CITY OF ALBUQUERQUE

Hydrology Section Planning Department
David S. Campbell, Director

**RE: ABCWUA Customer Service and Operations Facility - 6000 Alexander Blvd NE
G&D Plan and Drainage Report Engineer's Stamp Date 4/15/2019
Hydrology File: F16D014C**

The referenced submittal received on 4/22/2019 cannot be approved for Building Permit or Grading Permit. The following comments must be addressed prior to approvals.

4A CONNECTION TO EXIST 9' MANHOLE
C-500 N.T.S.

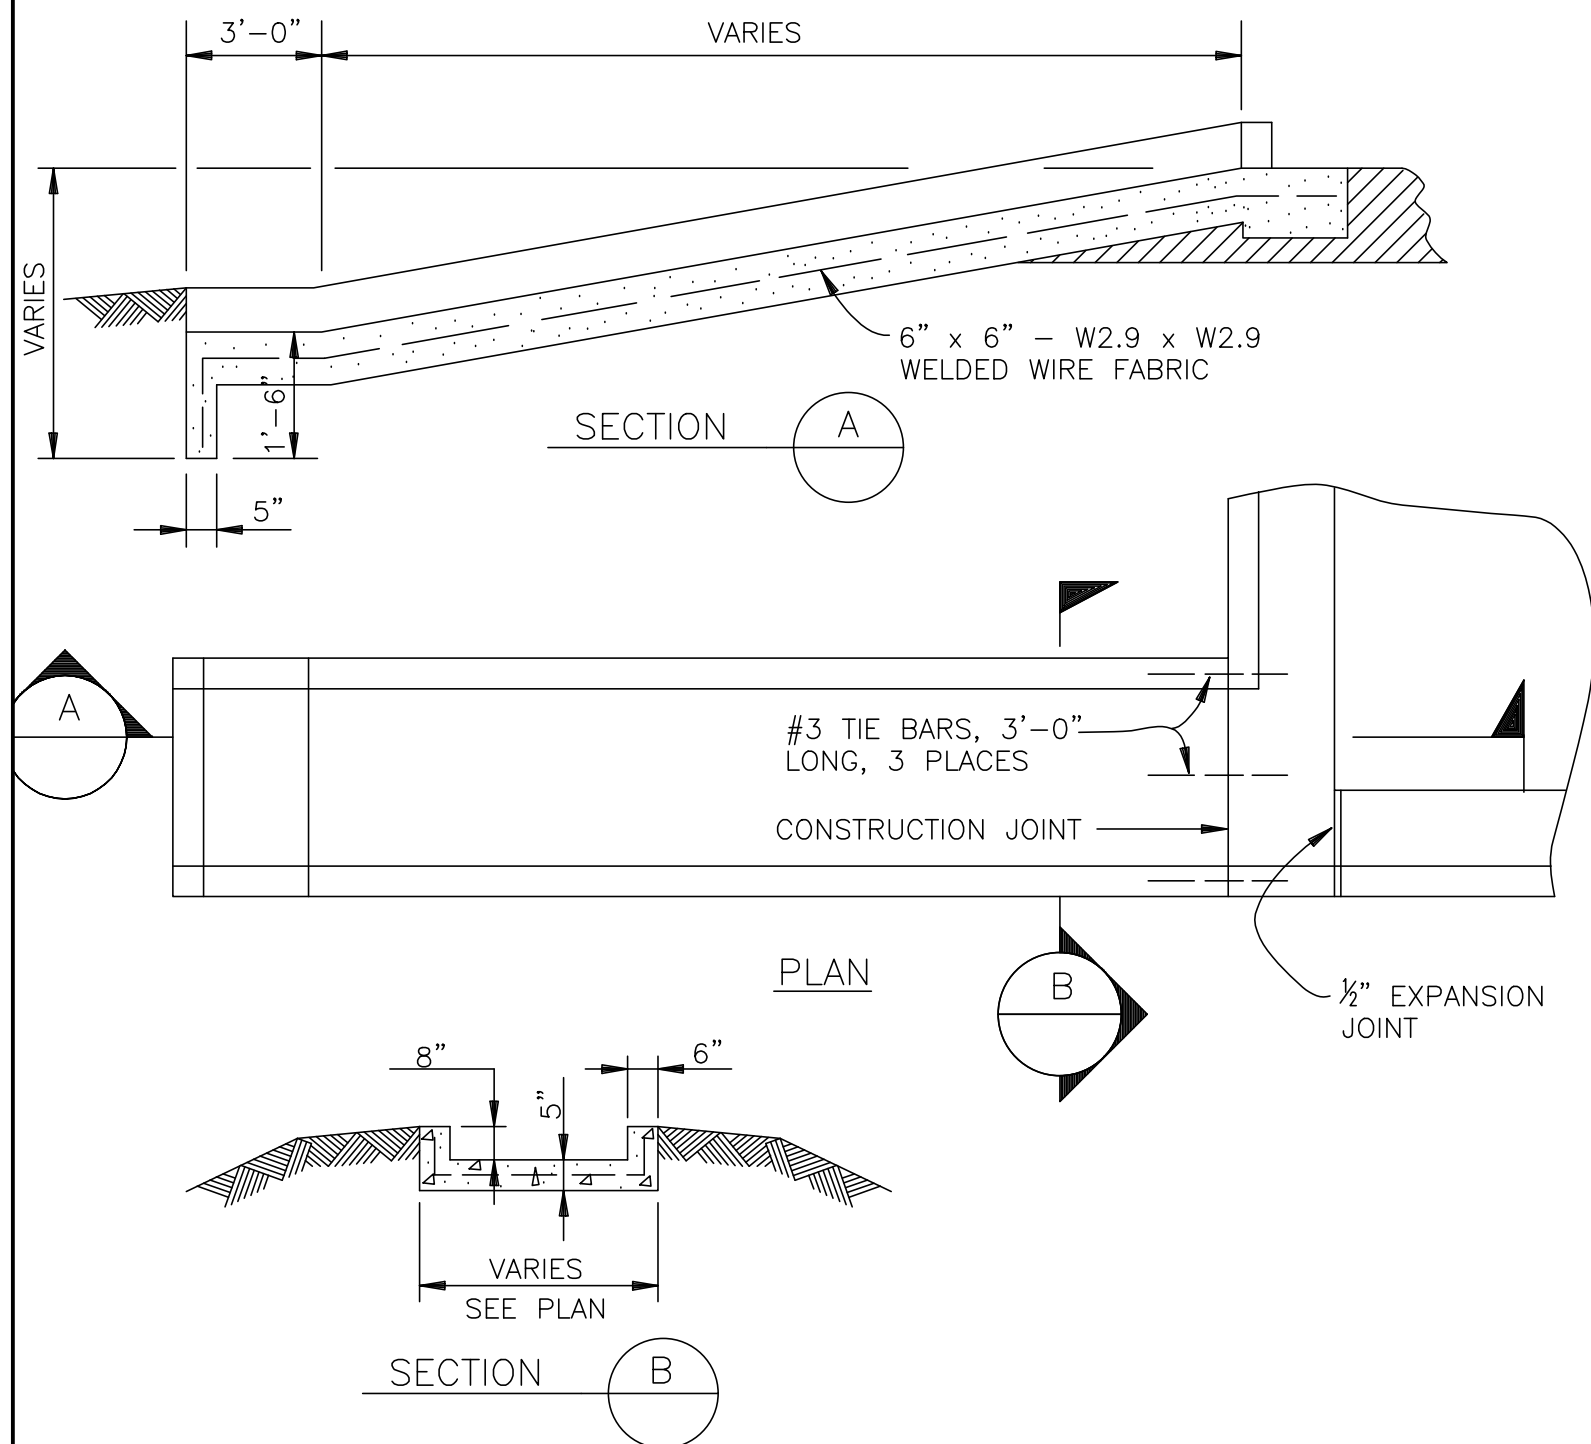
- 7) Where does the solar array basin drain to? Add a detail of the new storm drain junction structure at the north east corner of the new north pond.

MATCH LINE - SEE DWG C-301

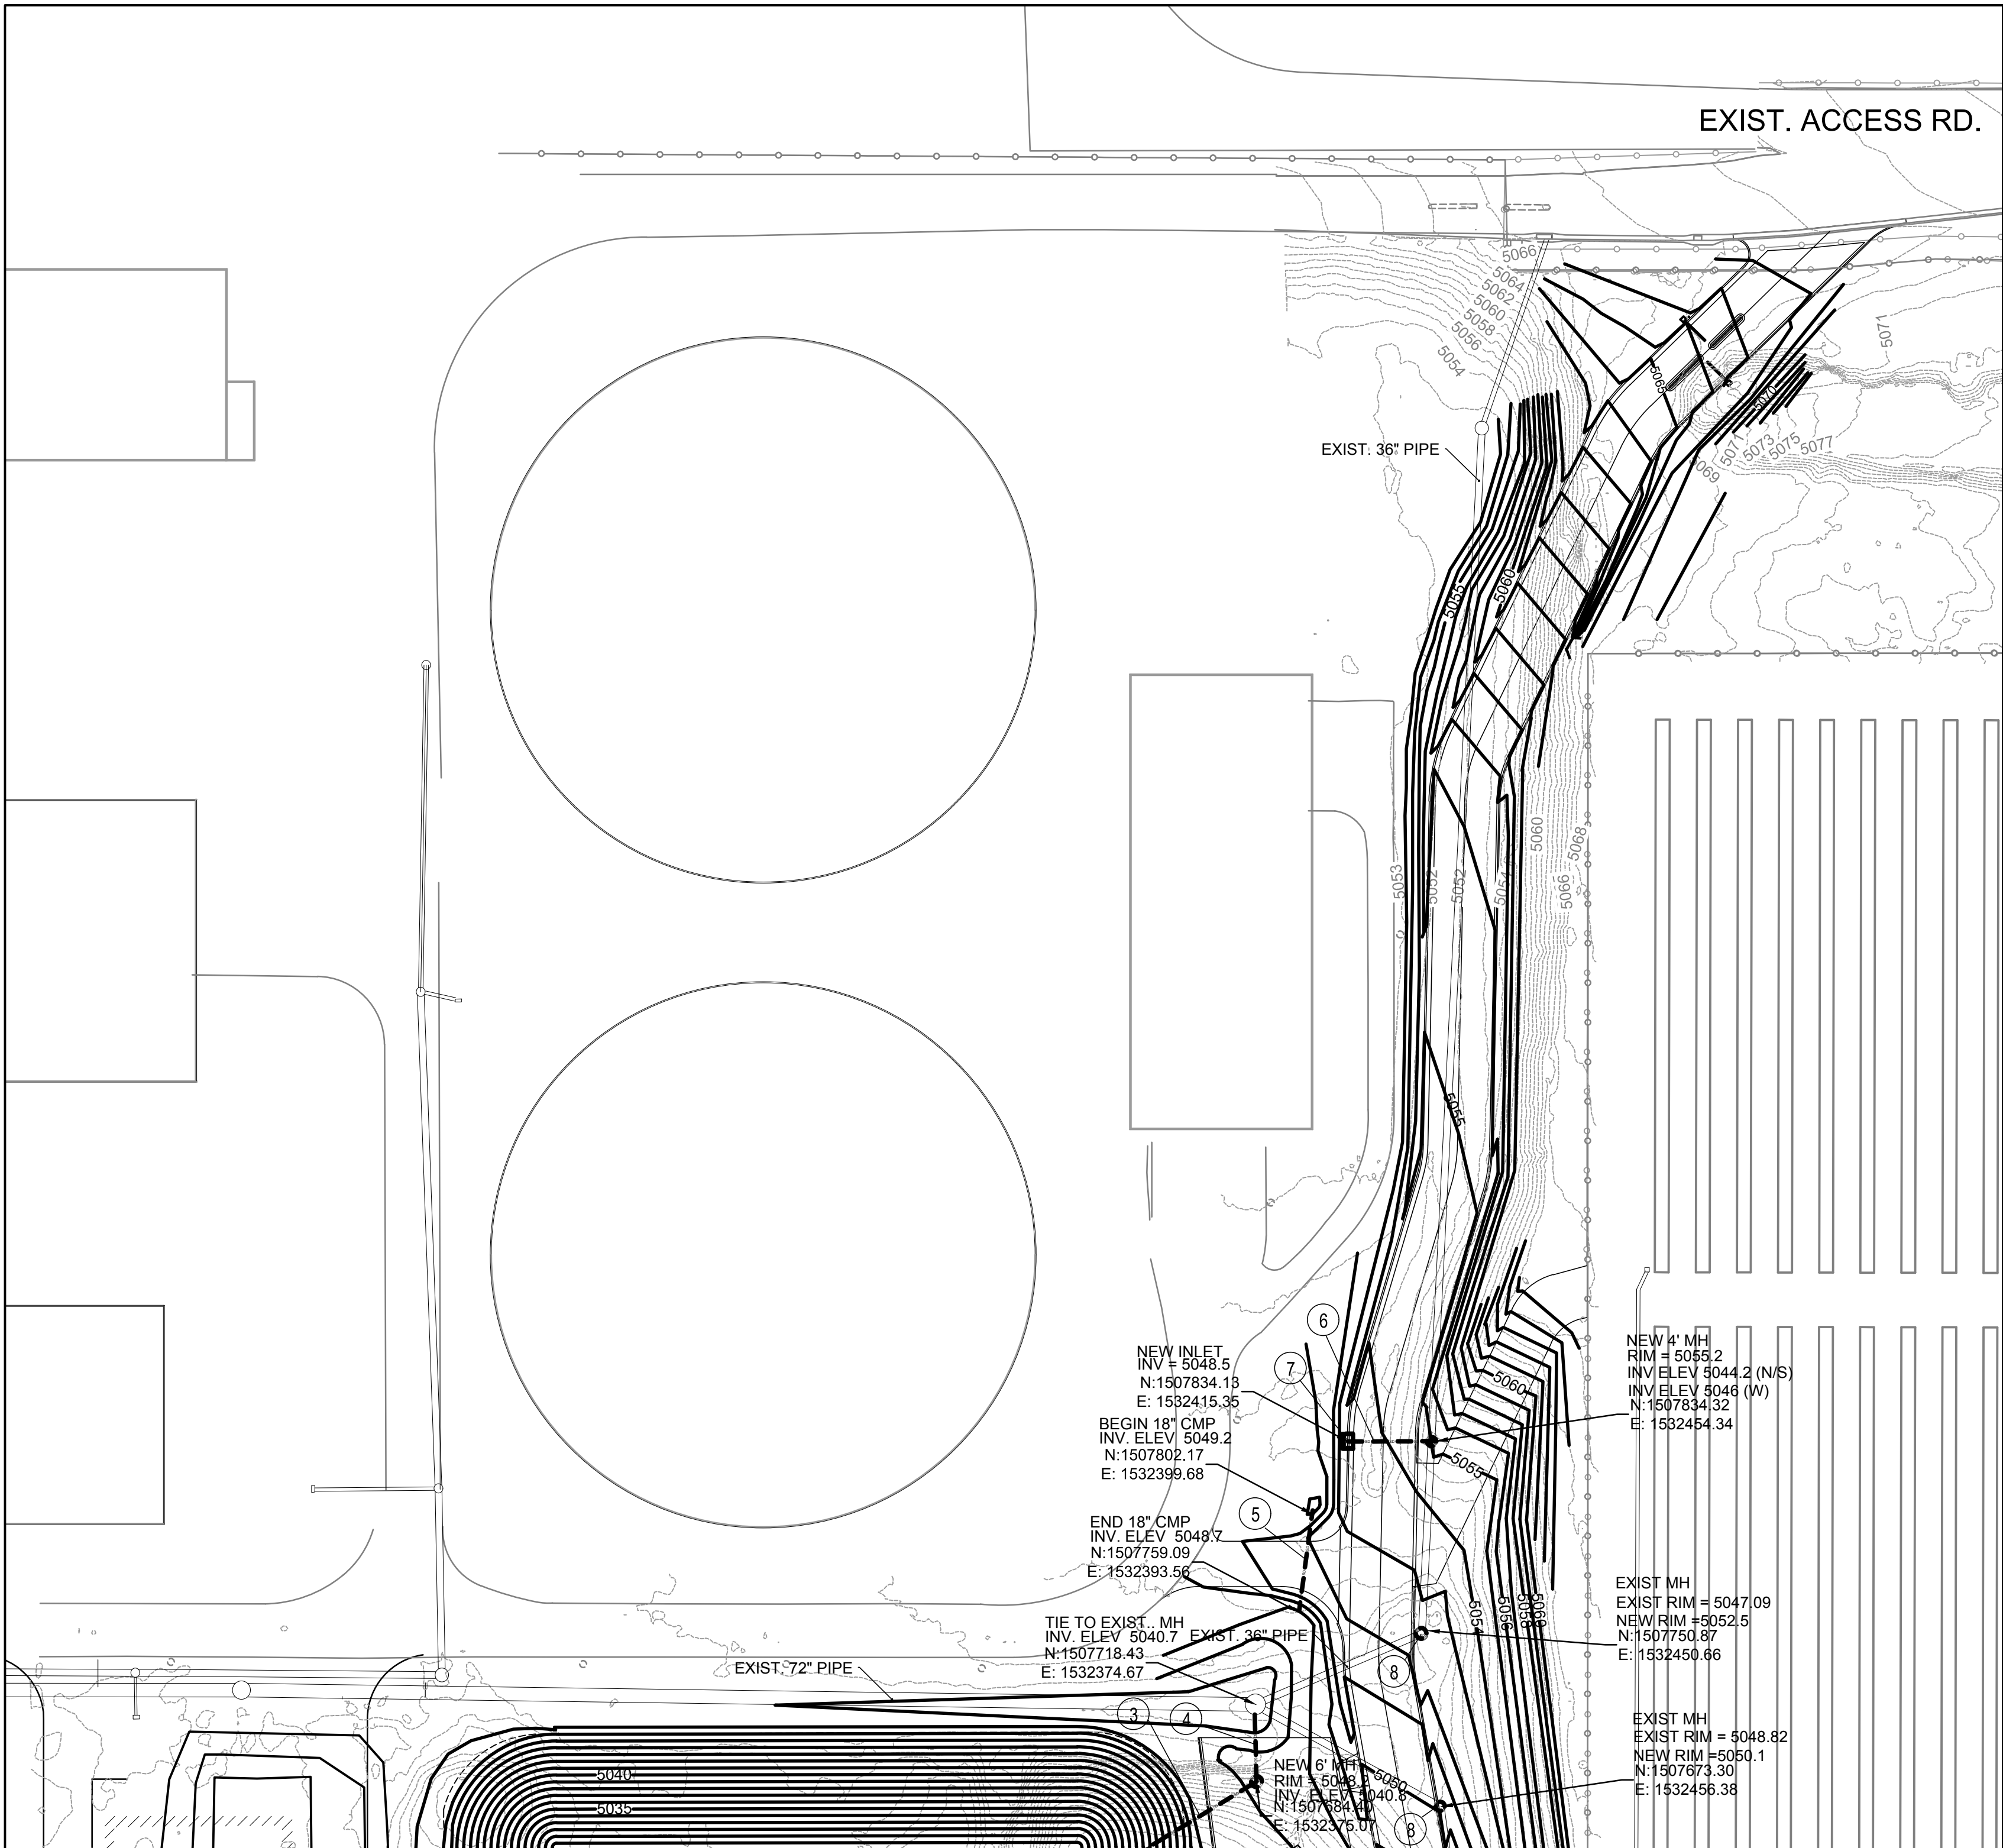
- 8) Provide 100 year hydraulic capacity calculations and details for each of the rundowns and curb openings. Identify the curb height in the parking lots.
